Charlotte Storm Water  
600 East Fourth Street  
Charlotte, N C 28202-2844

## *Rezoning Petition Review*

**Date of Review:** September 24, 2020 (***Revised October 23, 2020***)

**Rezoning Petition #:** 20-123

October 12, 2020

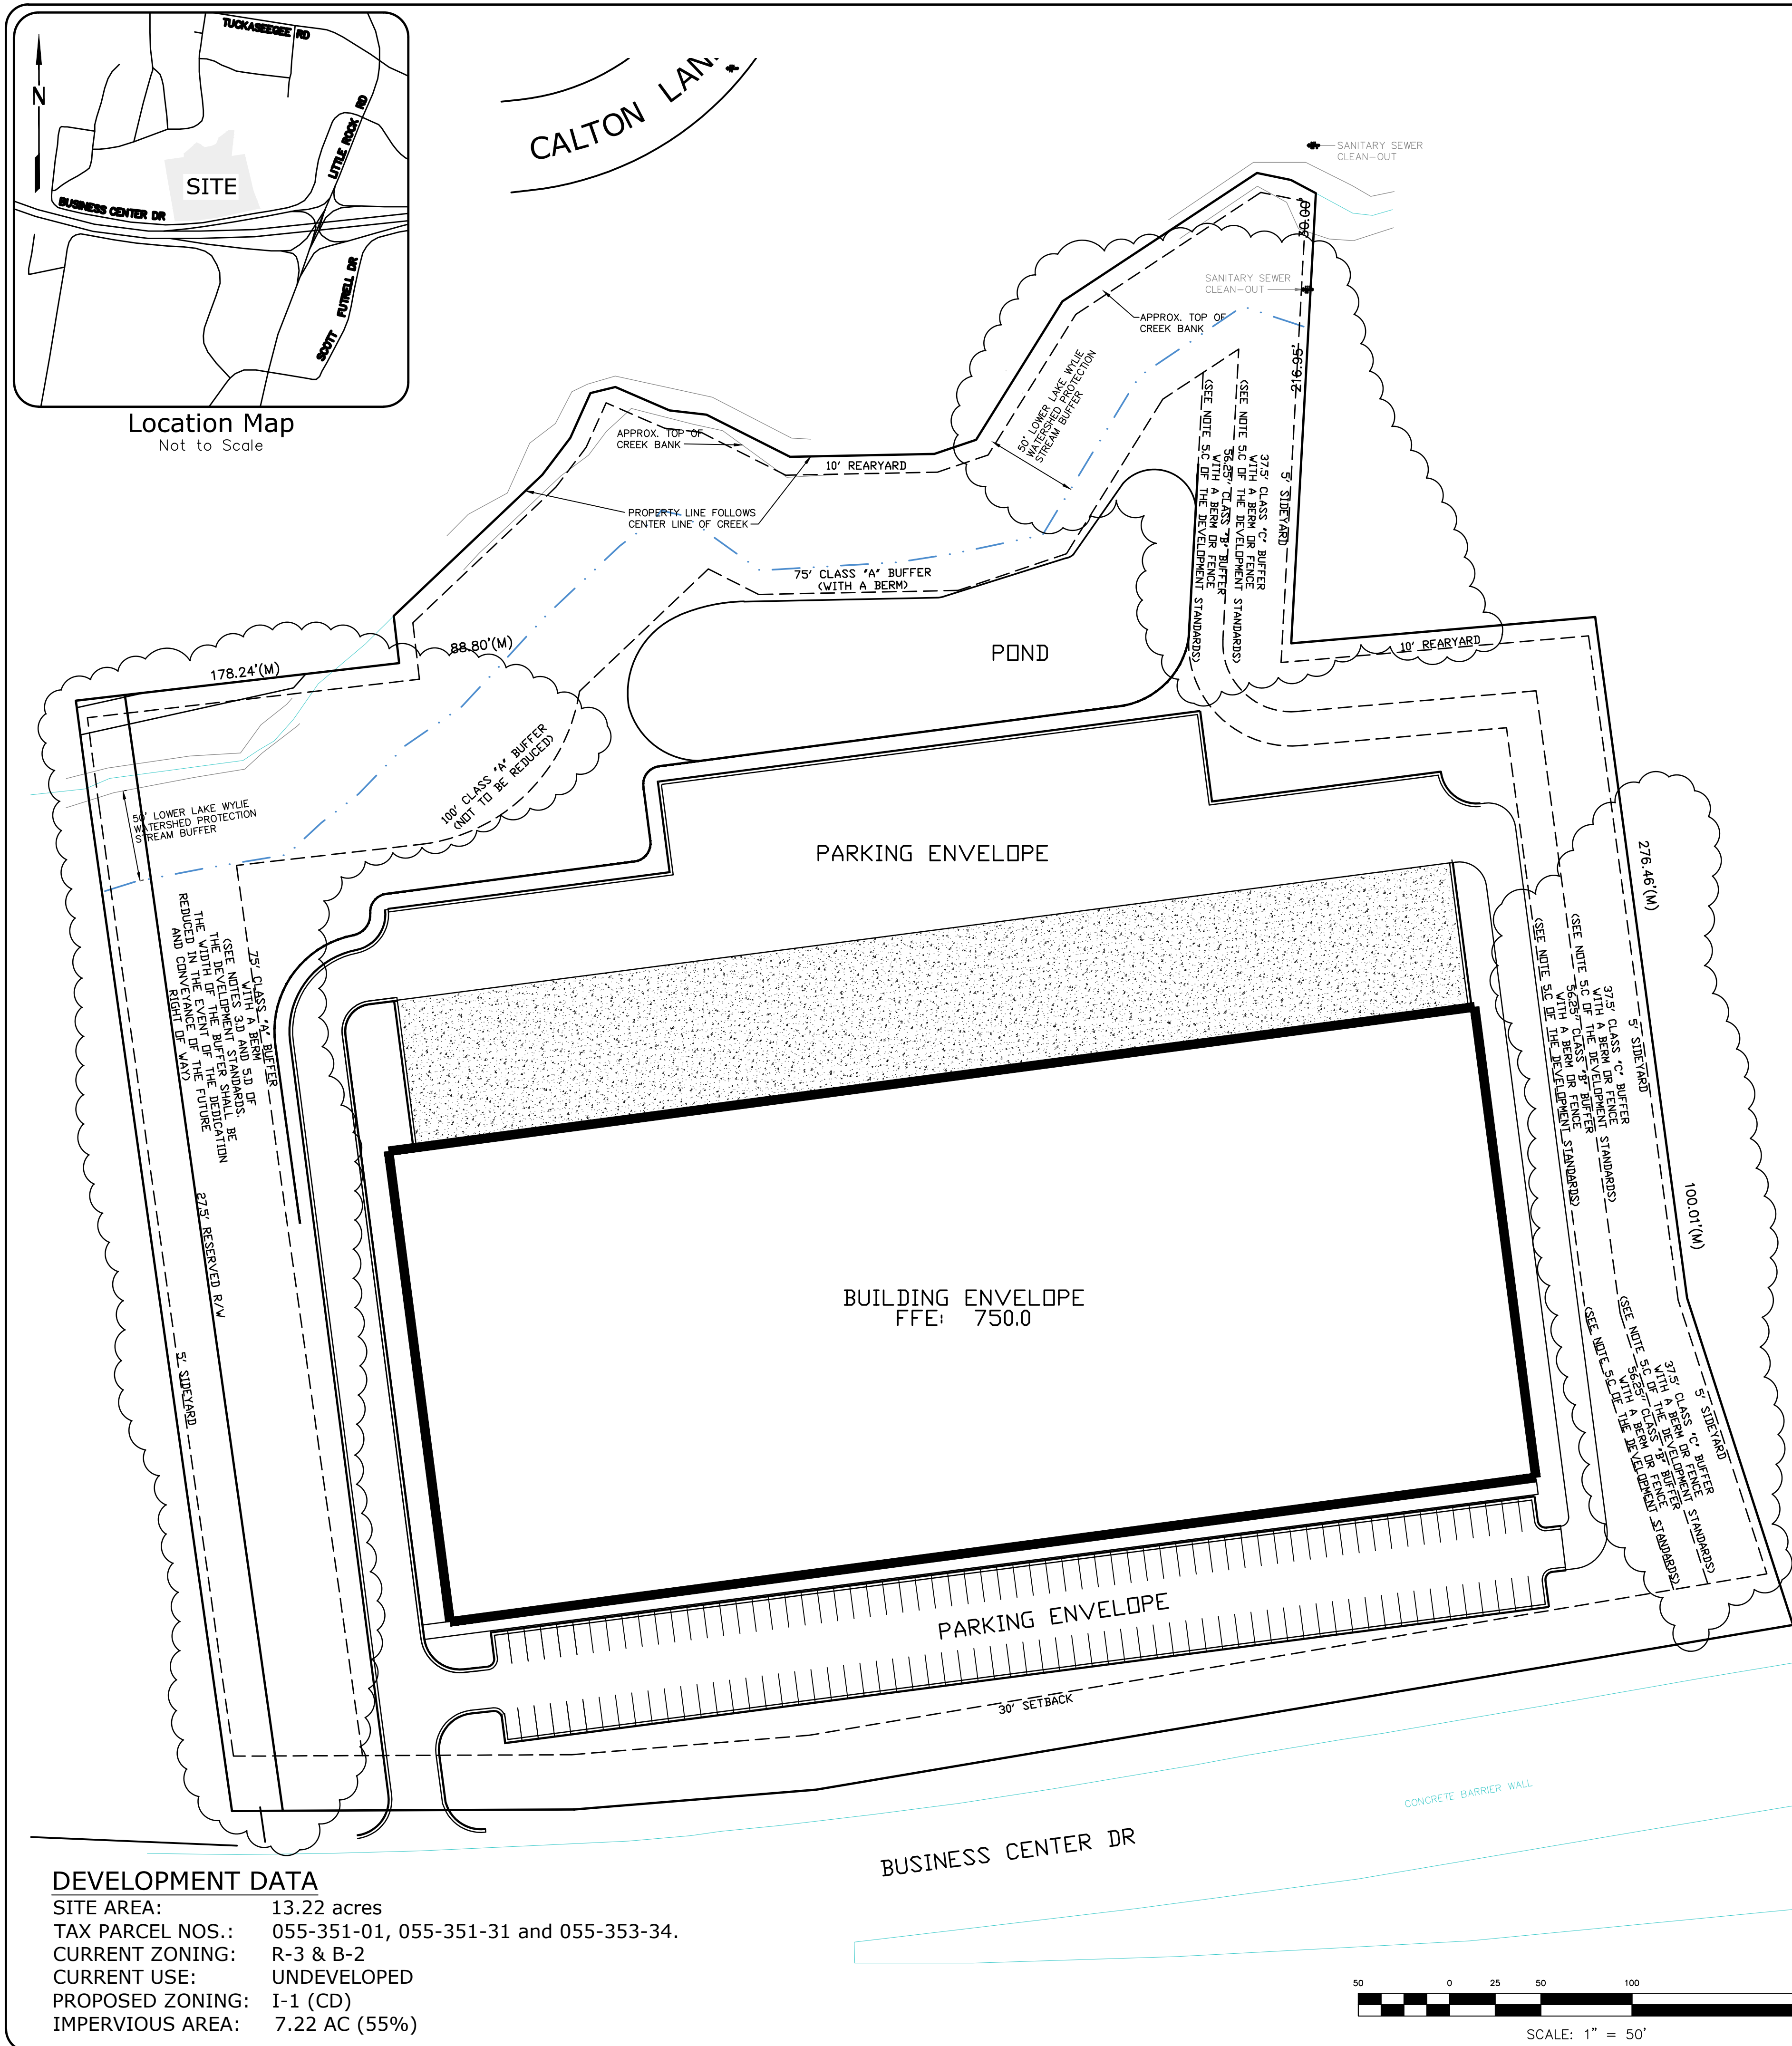
Stream buffers are incorrectly labeled. Applicability of stream buffer requirements will depend upon stream classification ("intermittent" stream will require 35' PCSO Buffer; "perennial" stream will require 100' watershed buffer). For purposes of advancing the rezoning process, please show and label "Potential 35' PCSO Stream Buffer" and "Potential 100' Undisturbed Lower Lake Wylie Watershed Protection Stream Buffer" on the rezoning plan OR provide stream delineation report confirming no intermittent or perennial stream exists (report subject to review and approval by City).

Please also add the following note under the ENVIRONMENTAL FEATURES heading:  
*"Development within any PCSO/Watershed Protection Stream Buffer shall be coordinated with and subject to approval by Charlotte-Mecklenburg Storm Water Services and mitigated if required by City ordinance. Petitioner acknowledges intermittent/perennial stream delineation reports are subject to review and approval upon submission of development plans for permitting and are not approved with rezoning decisions."*
